DRB Application No.: 10DRB-70353 Project # 1004367
 Project Name: Calaveras Addition
 Agent: Forstauer Surveying Co. LLC Phone No.: _____

CITY OF ALBUQUERQUE
PLANNING DEPARTMENT
December 22, 2010
DRB Comments

RE: Lots 63 – 65, Calavero Addition, plus Tracts 48 & 49,
MRGCD Map # 29

Improvement Sketch

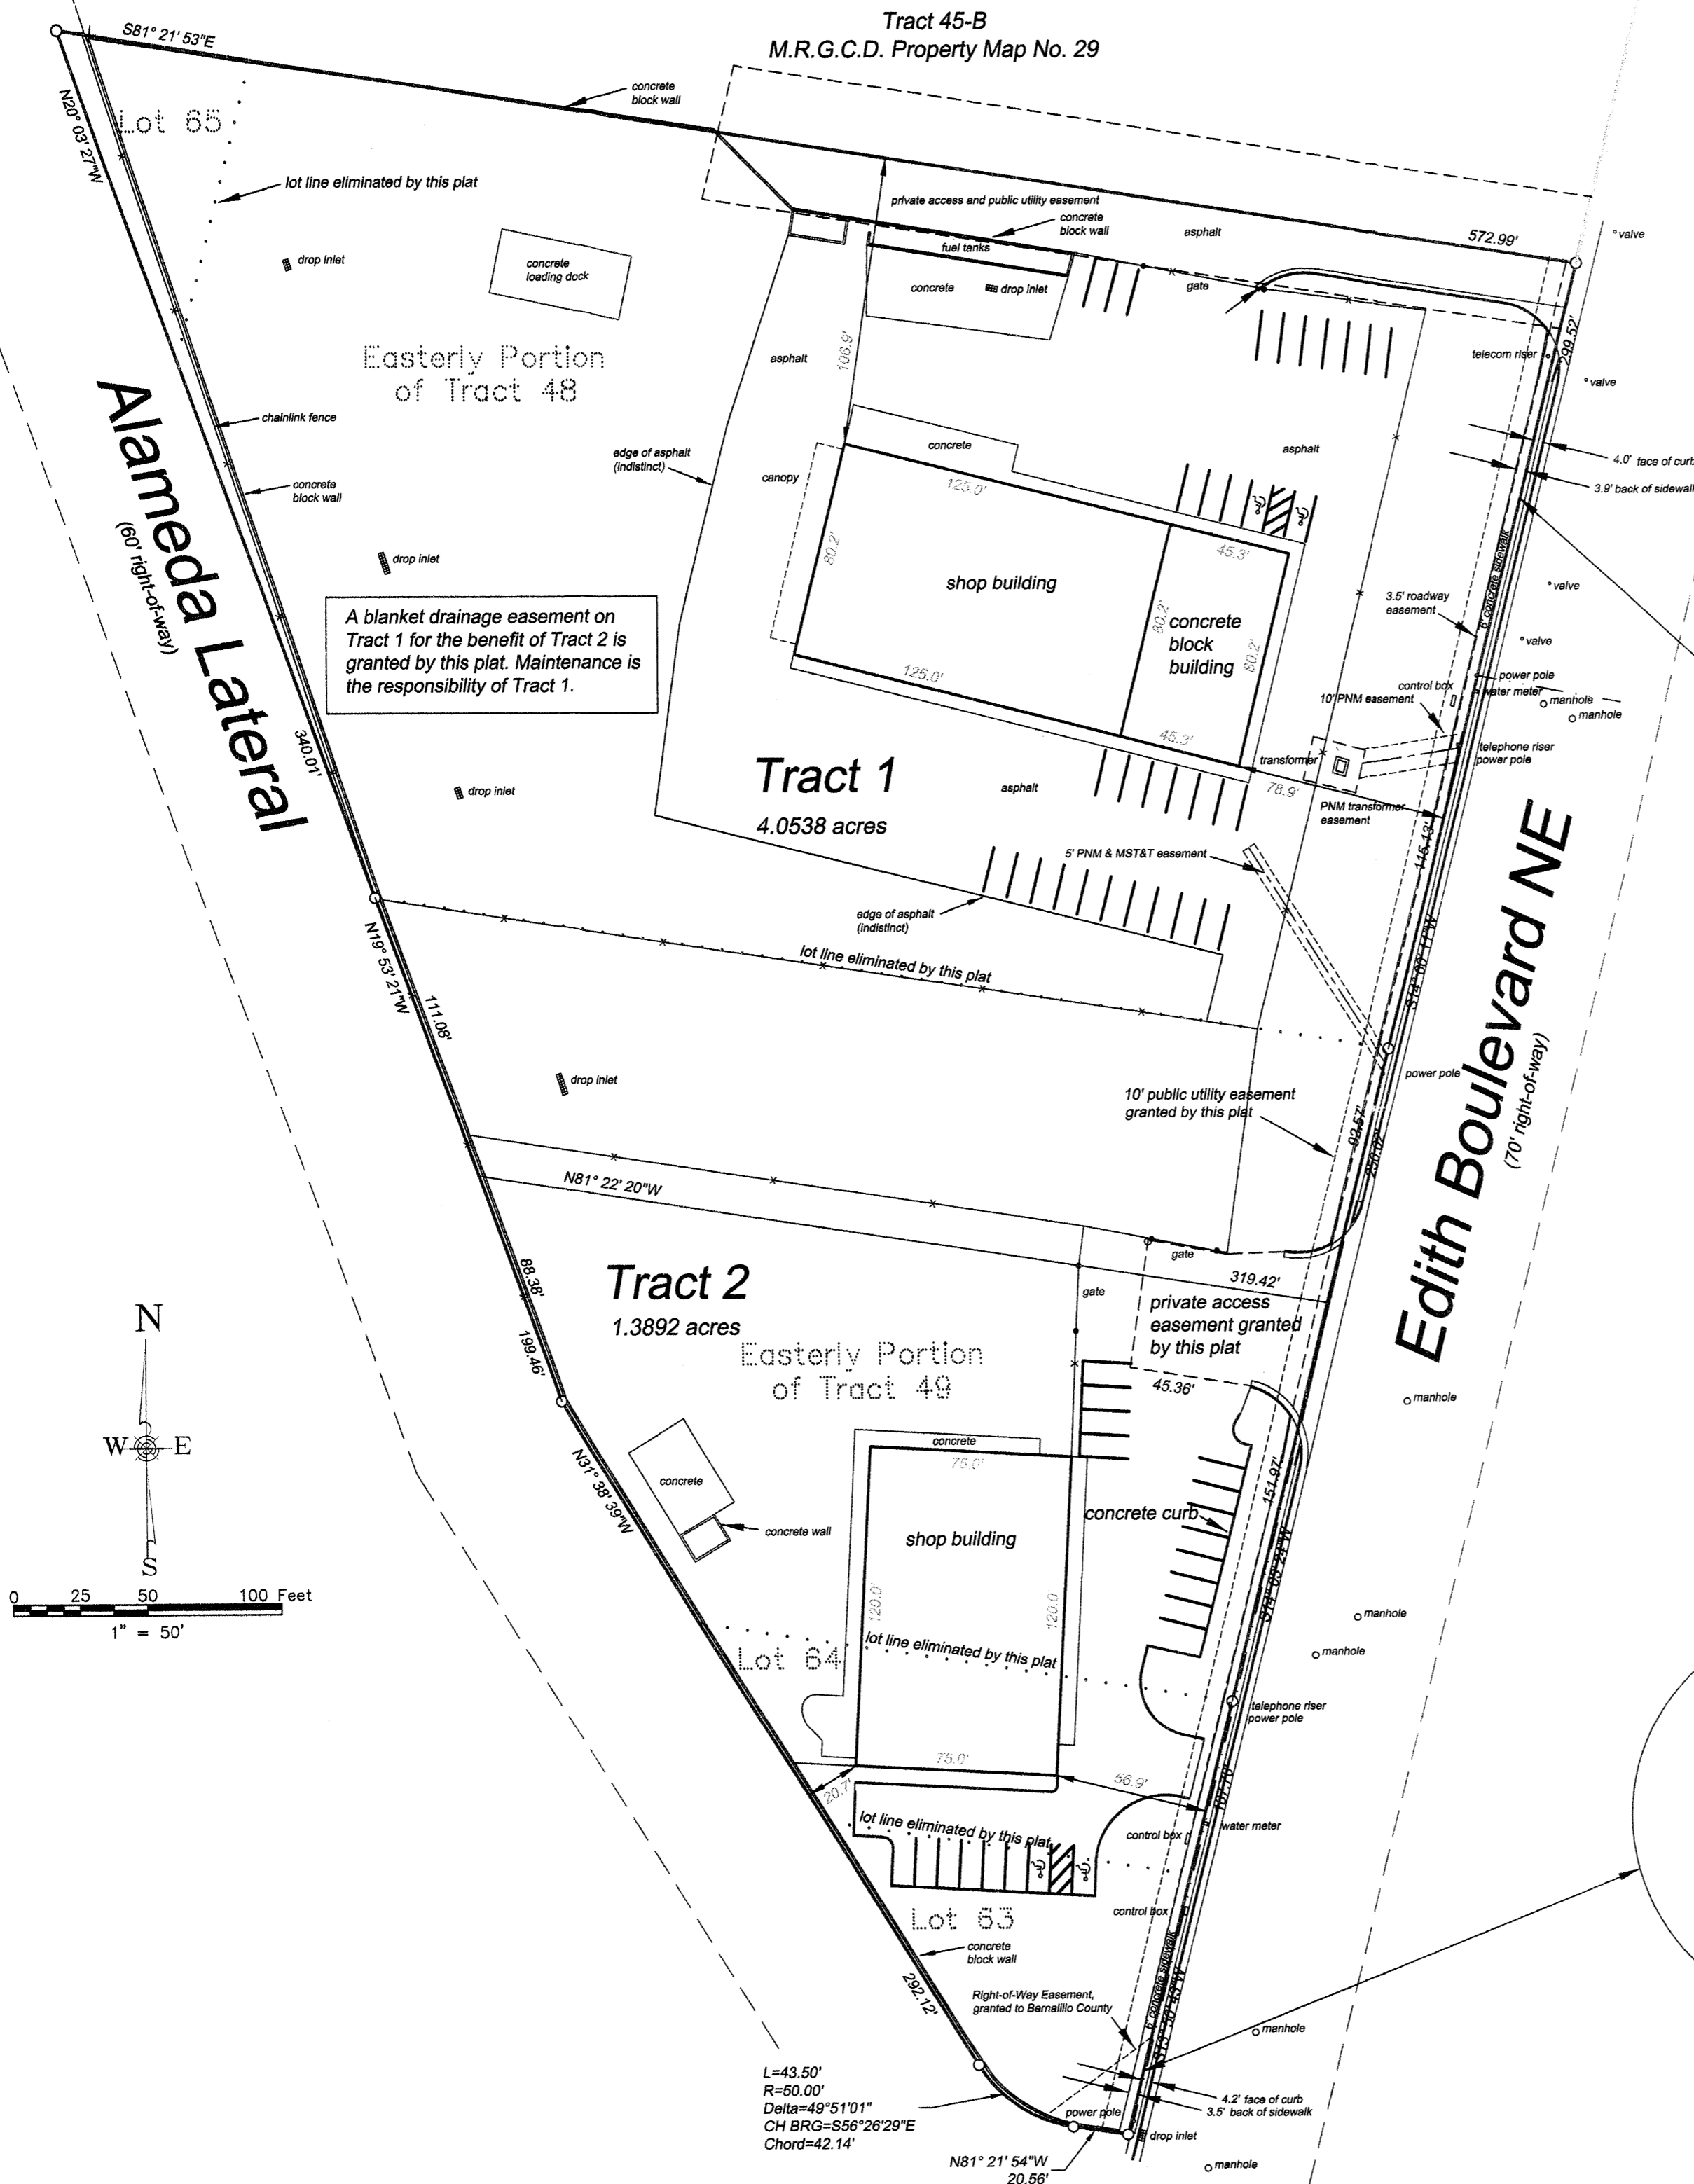
TRANSPORTATION: resolve R-O-W / Easement for Edith

**6609 and 6613 EDITH BLVD.
 SITE DEVELOPMENT PLAN**

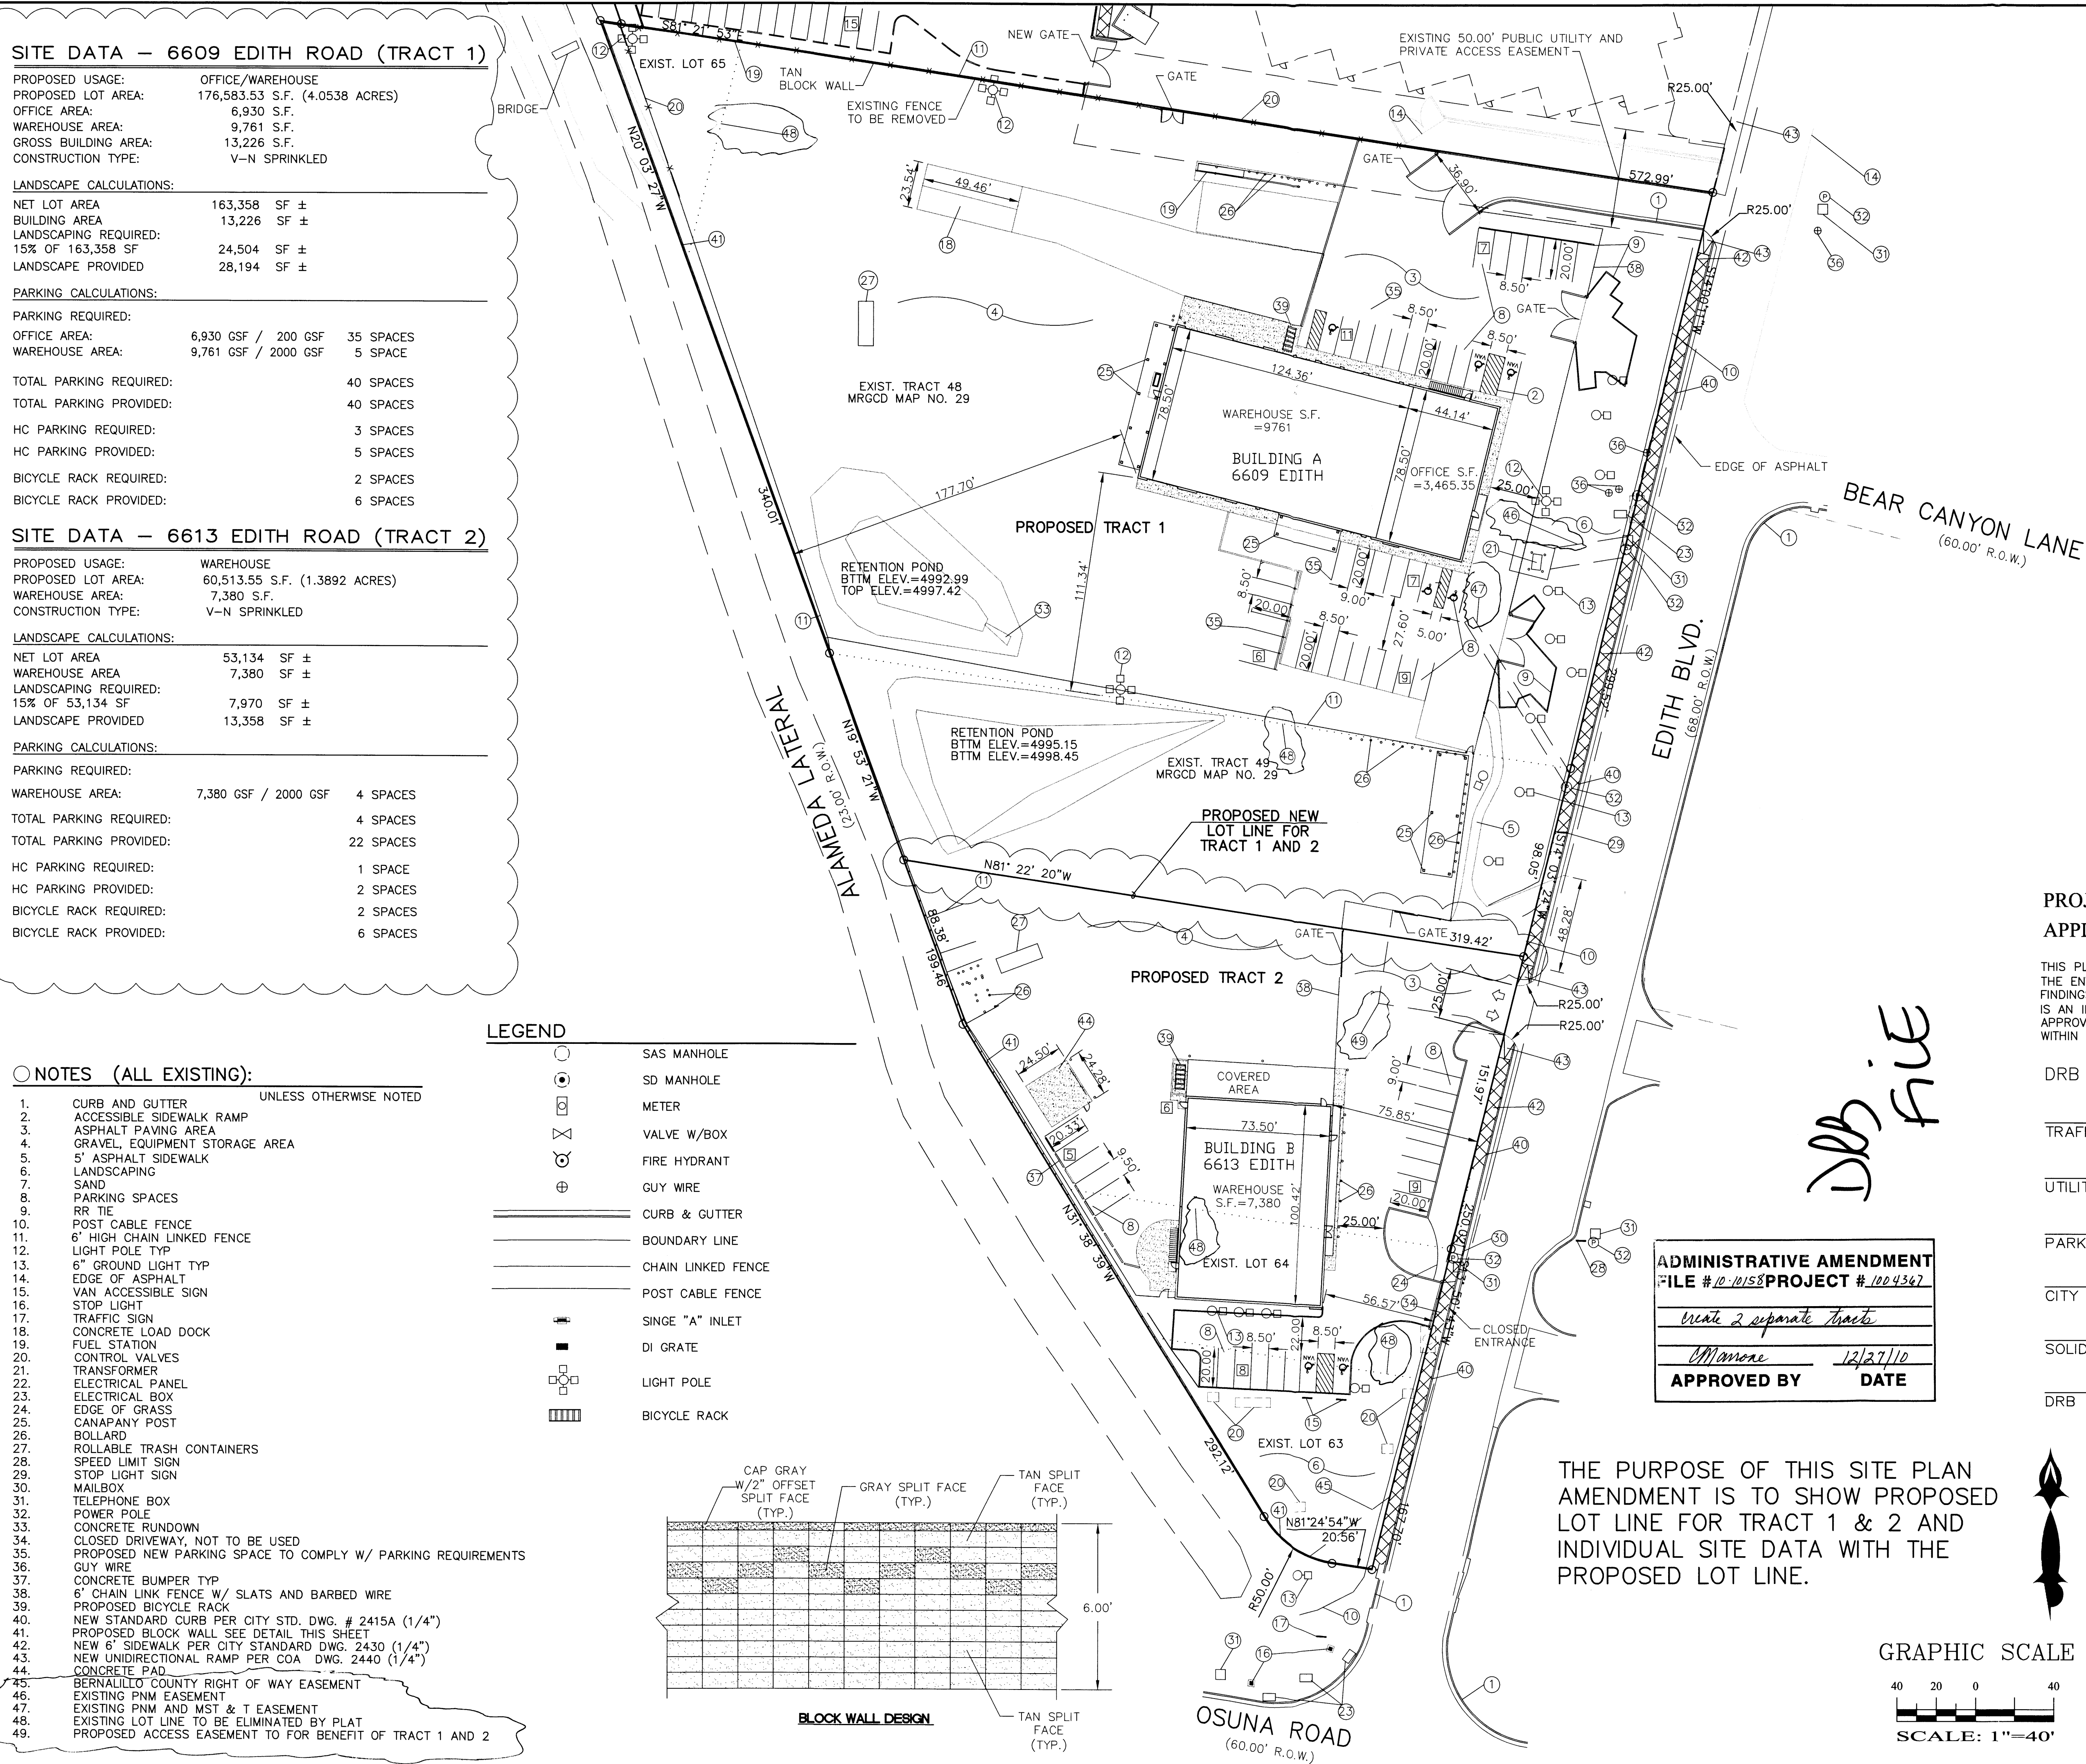
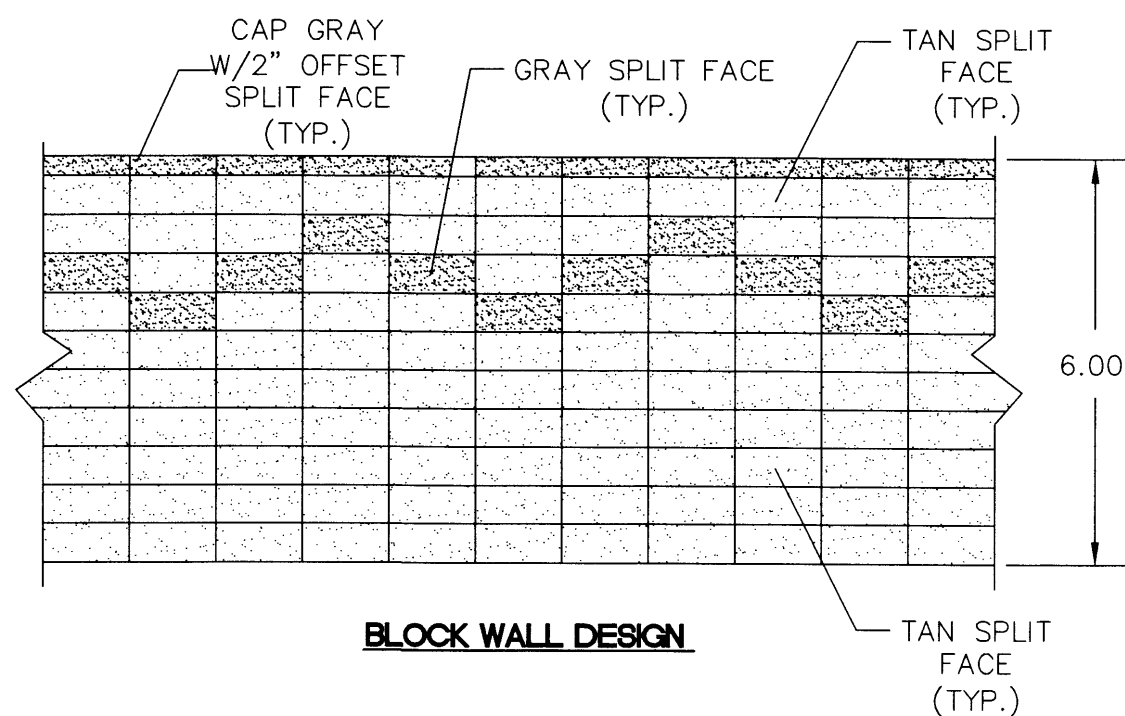
This site is zoned SU-1; per § 14-14-2-2 of the Subdivision Ordinance, platting must conform to an approved site plan. The proposed lot line might be acceptable for an Administrative Amendment (to show the proposed subdivision) – the parking calculation table would need to be verified for each lot to meet its required parking.
